September 22, 2016

SUBJECT: Response to August 23, 2016 Review of NCDOT's application for Section 404 and 401 permits for the proposed improvements to NC 3 (Mooresville Road), from Kannapolis Parkway to Dale Earnhardt Boulevard/Loop Road (SR 1691), Cabarrus County, North Carolina. Tip No. U-3440.

Reference: NCDWR On-Hold letter, dated August 23, 2016
NCDOT 404 & 401 Application dated June 16, 2016

PROJECT REFERENCE NO. U-3440		SHEET NO. 9	
RW SHEET NO.		HYDRAULICS ENGINEER	
ROADWAY DESIGN ENGINEER		ENGINEER	
10/4/2016		10/5/2016	
DOCUMENT NOT CONSIDERED FINAL UNLESS ALL SIGNATURES COMPLETED

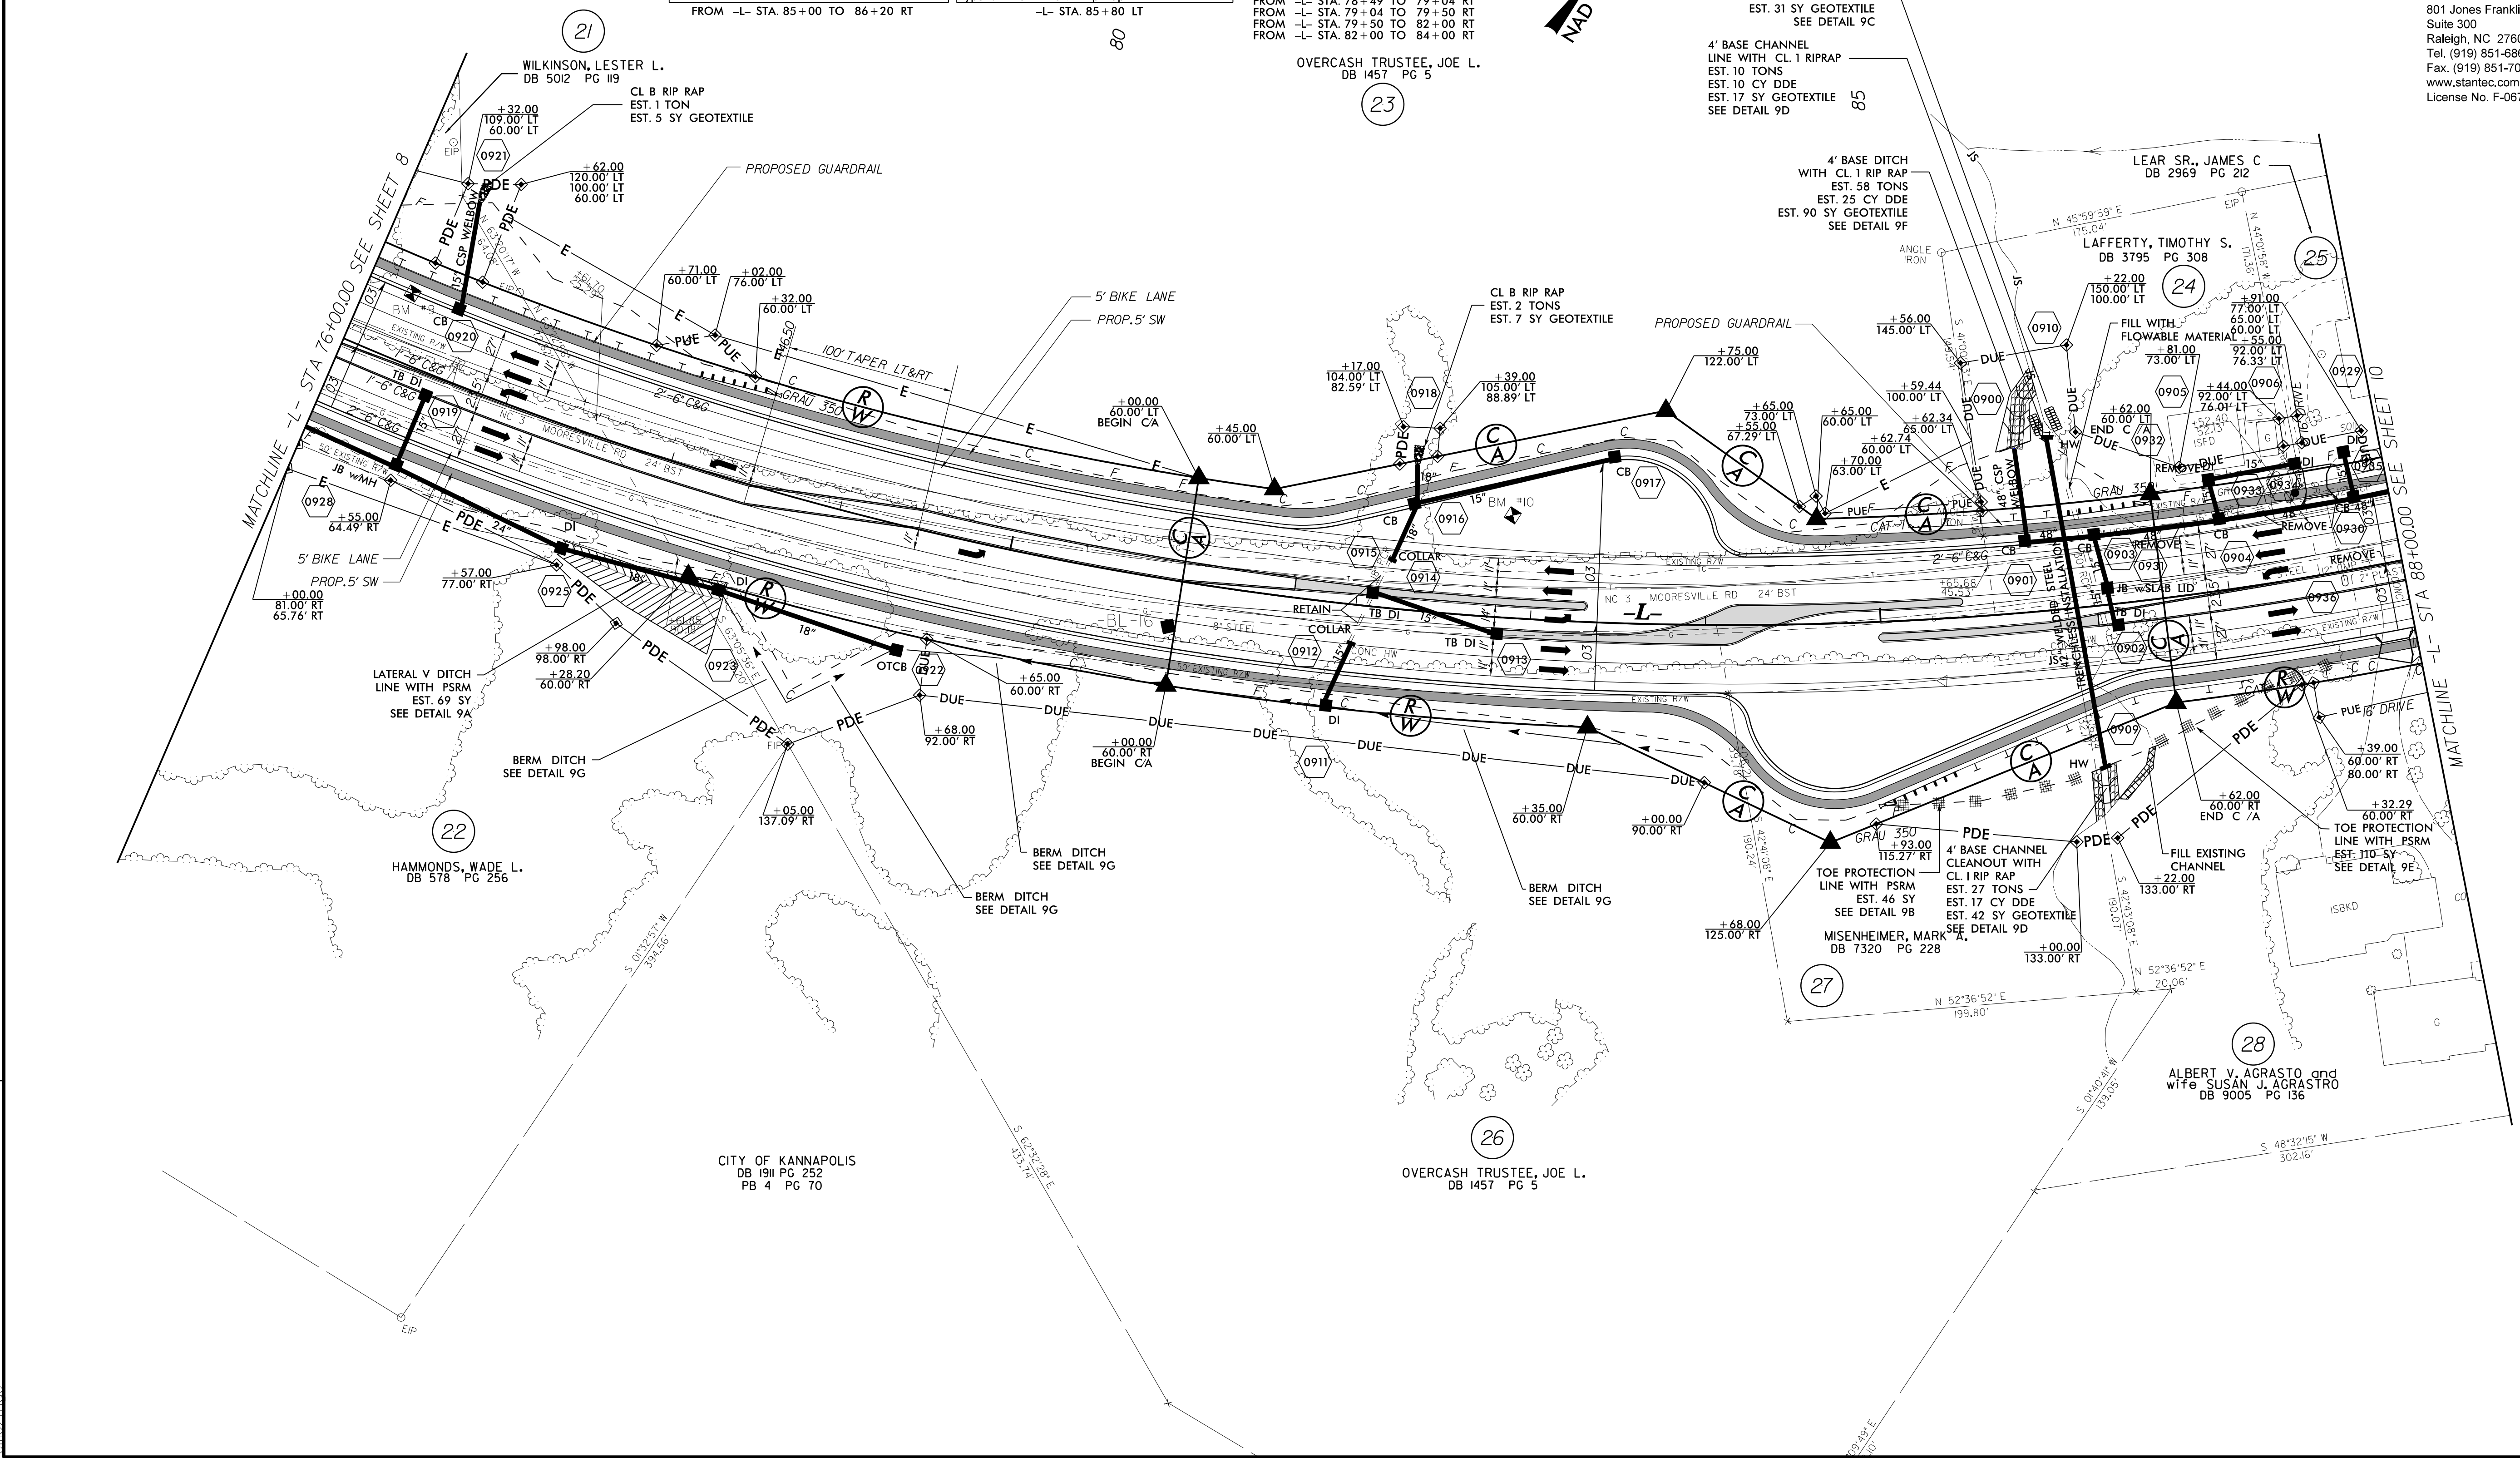
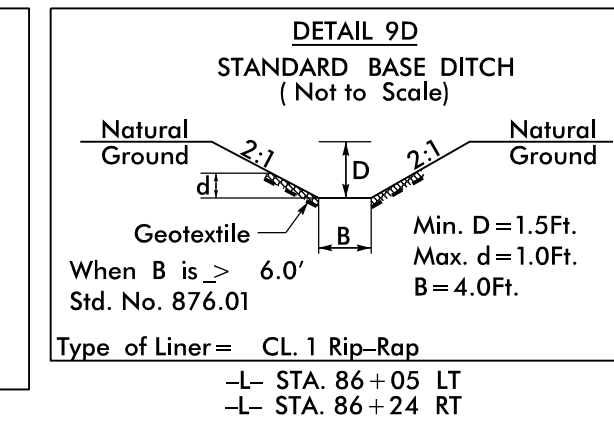
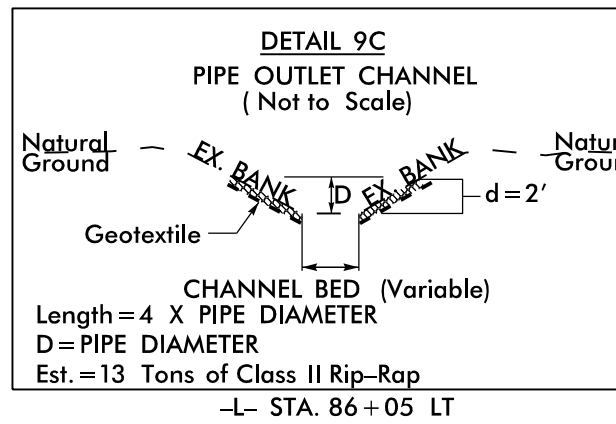
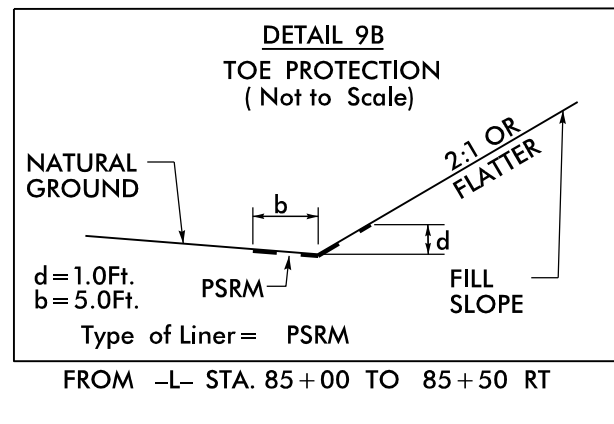
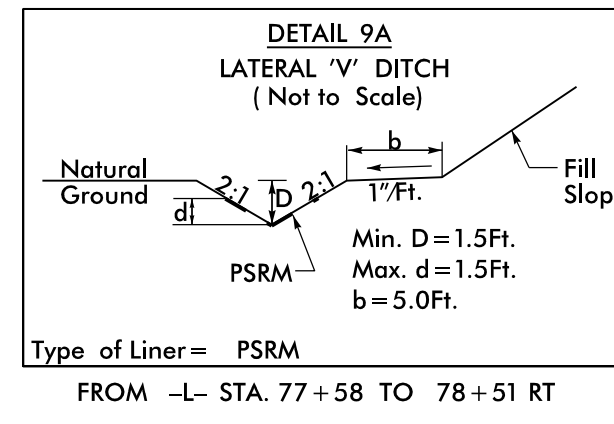
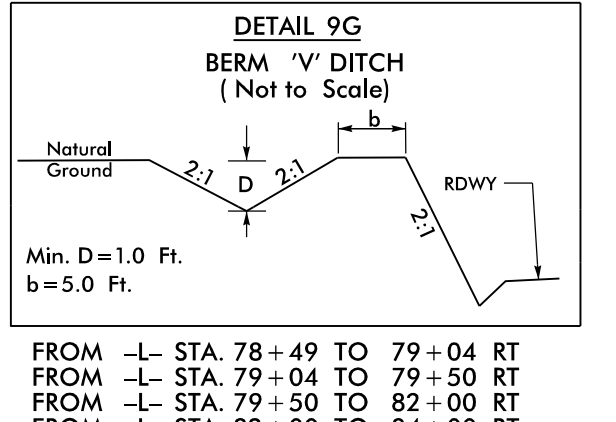
- NCDWR Comment: Detail for directing flow into the 42-inch bored pipe at Site S3.
 - NCDOT Response: Detail D is the detail used to direct flow into the pipe at the upstream end (Station 86+24 Rt.). This same detail has been added to the downstream end of the pipe (Station 89+05 Lt.) to convey water from the pipe back into the stream.

DOCUMENT NOT CONSIDERED FINAL
UNLESS ALL SIGNATURES COMPLETED

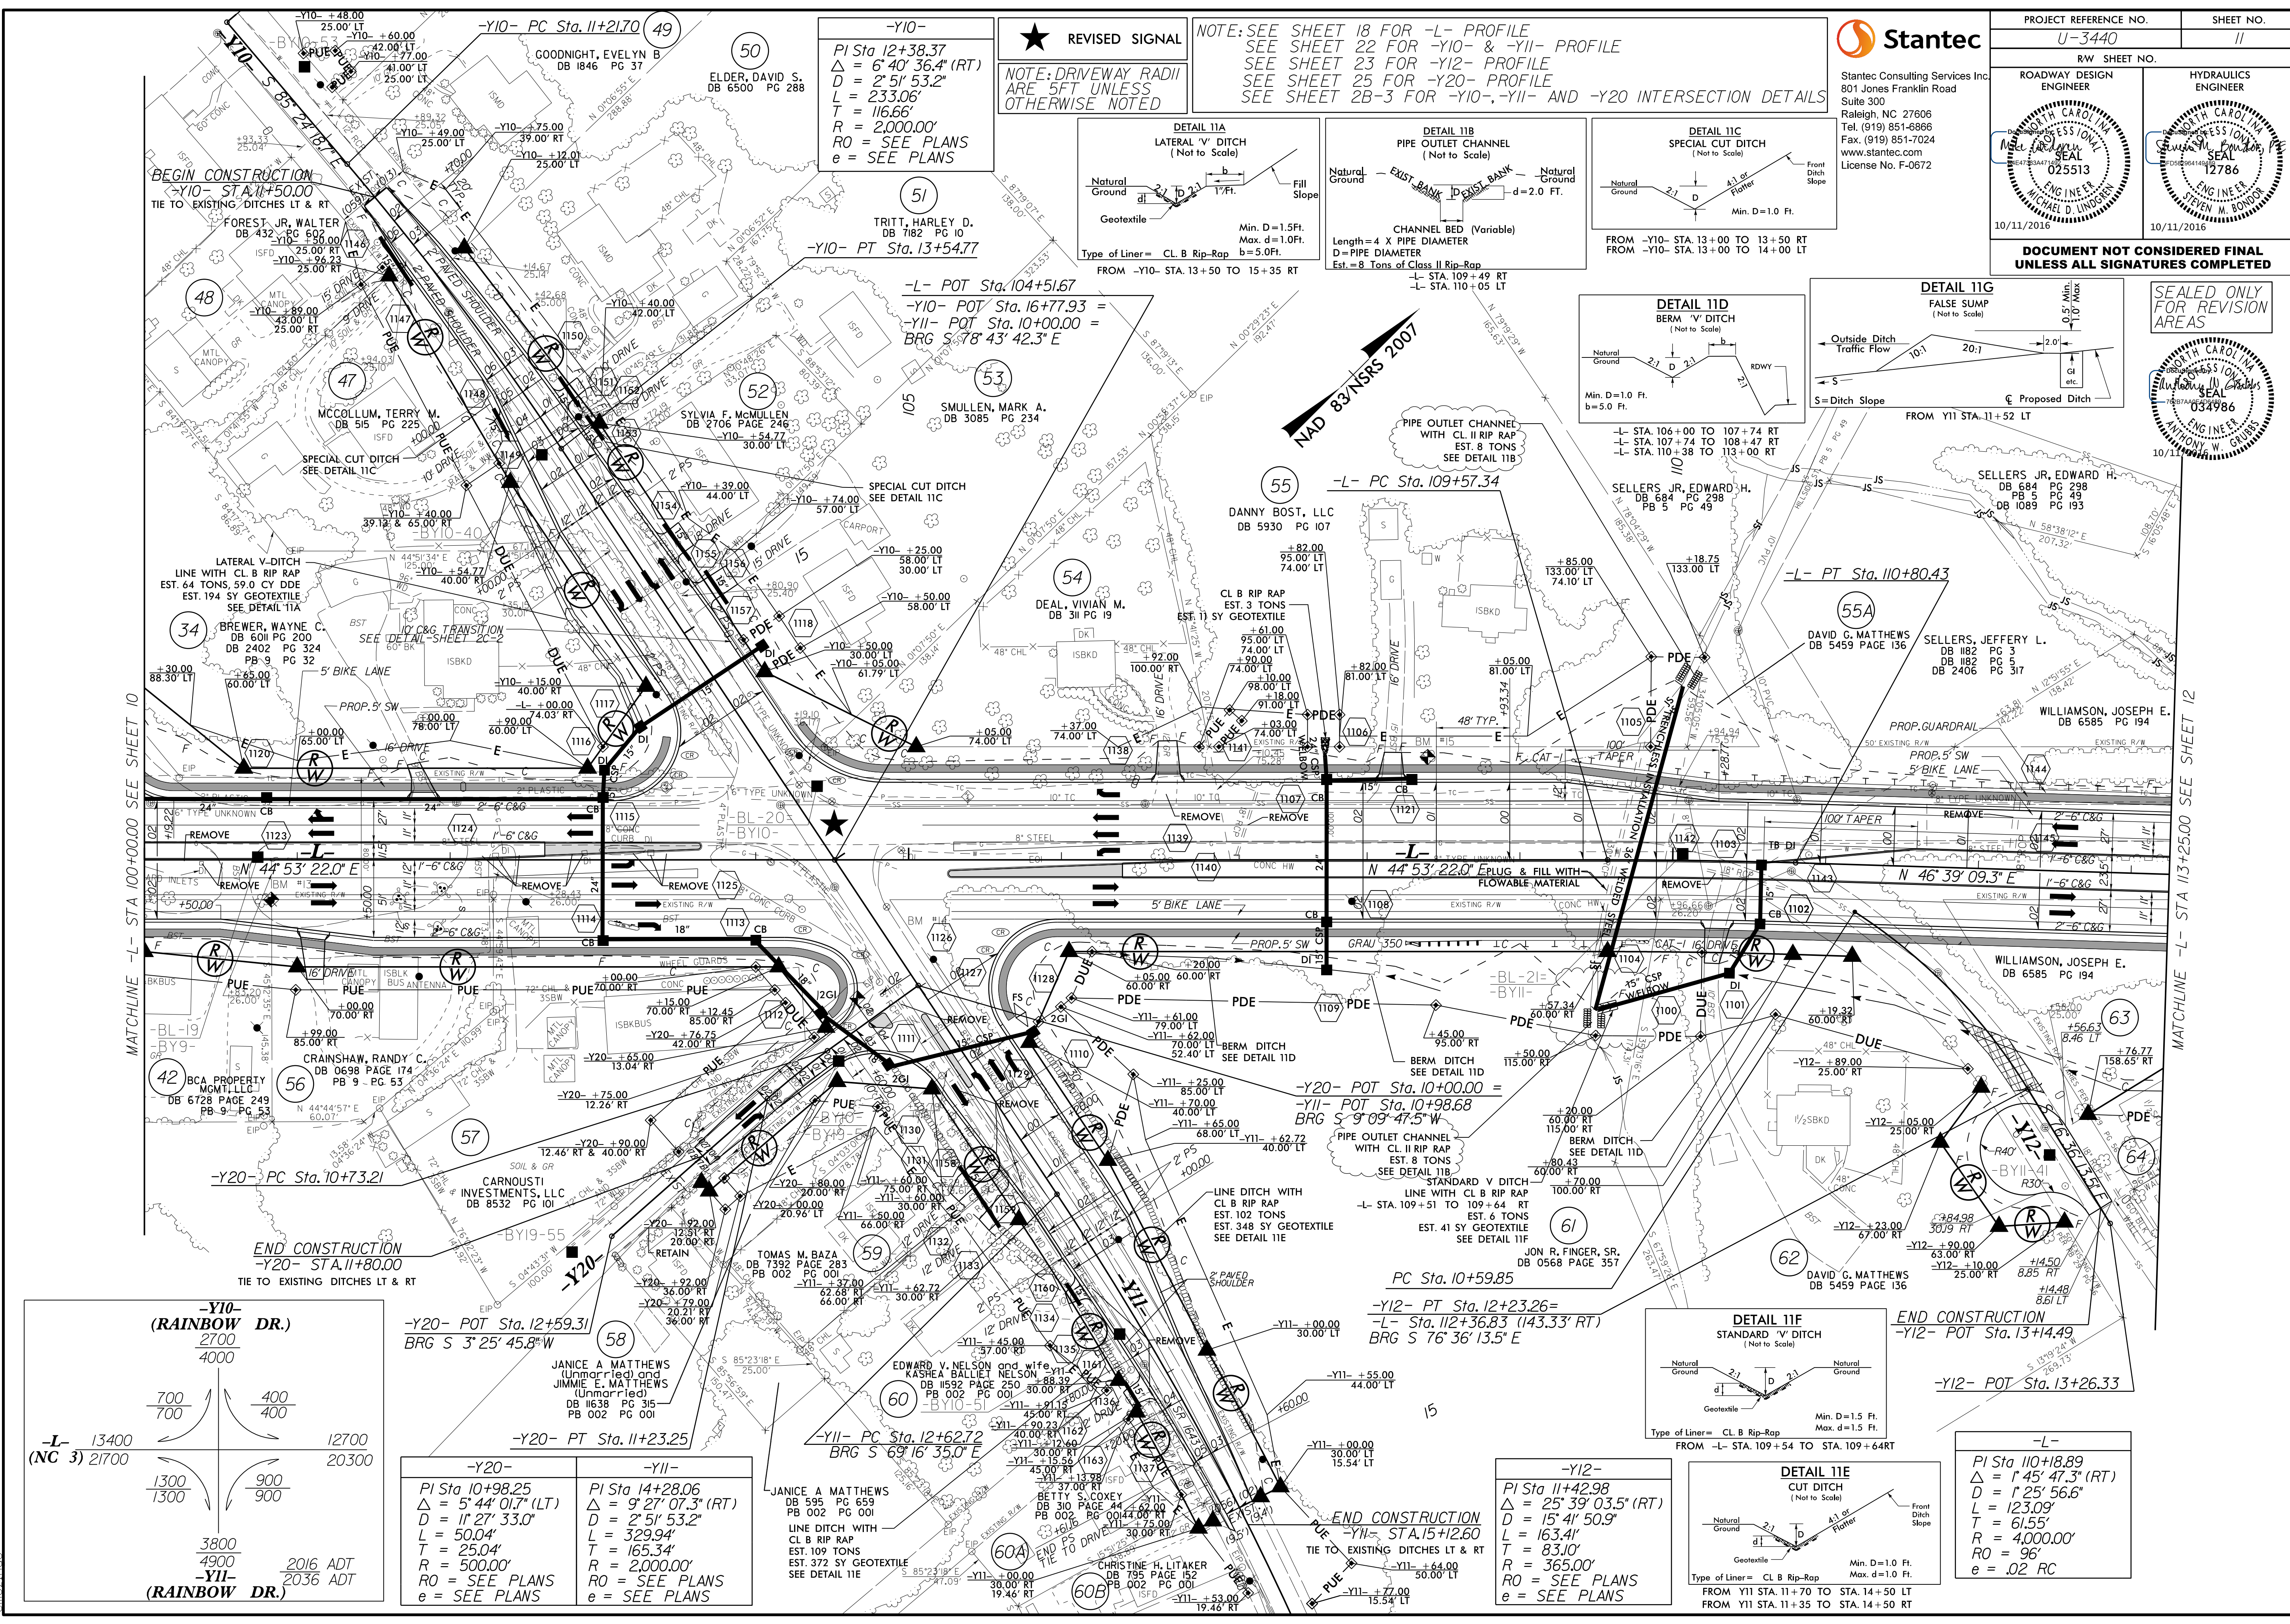
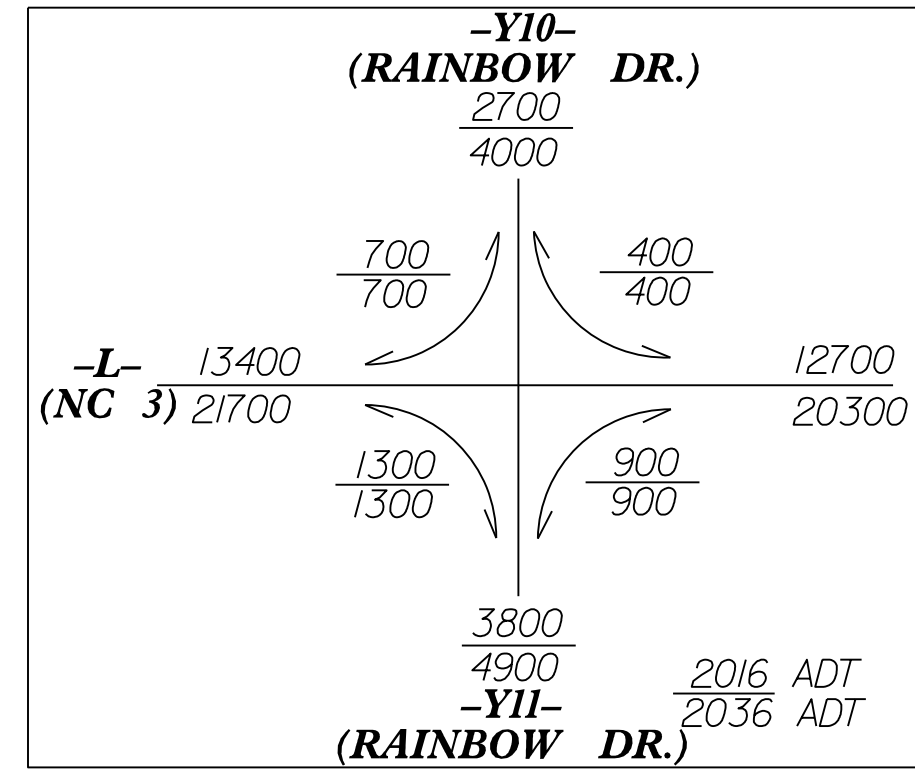
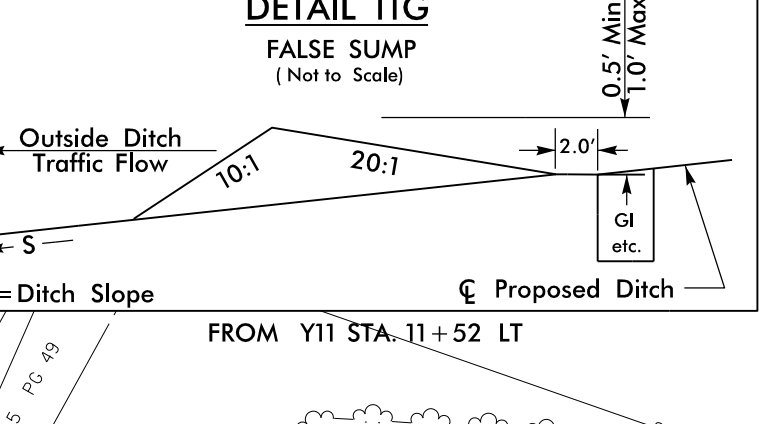
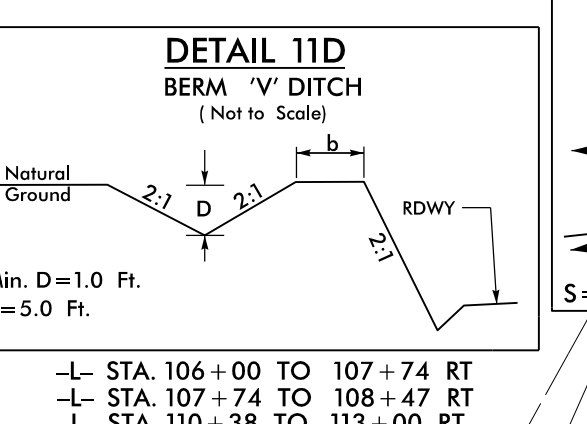
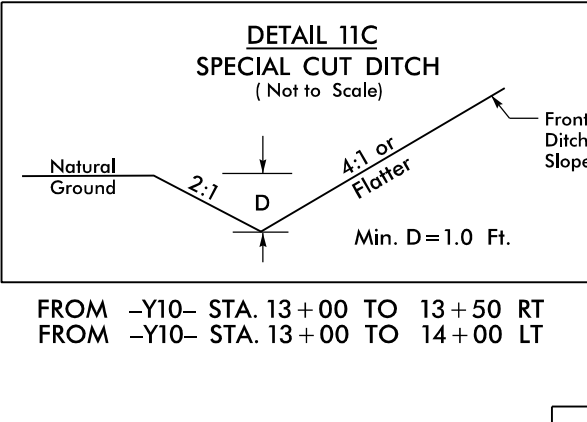
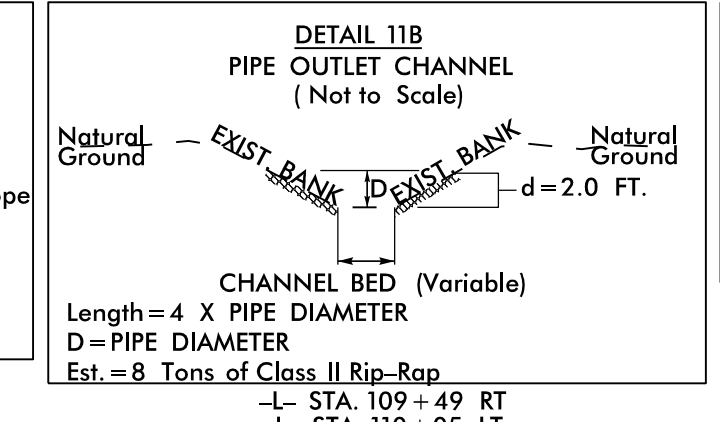
- NCDWR Comment: Please provide detail at Site S5 for turning flow from 15' CMP into stream.
 - NCDOT Response: A short riprap ditch (armored tail ditch) has been added at the outlet of the 15-inch CMP (see Detail 11F).

- NCDWR Comment: Recommend Class 2 riprap for bank stabilization at S5 due to a very steep grade.
 - NCDOT Response: Class I riprap is adequate for this crossing. The armored tail ditch (see comment above) will provide additional stability.
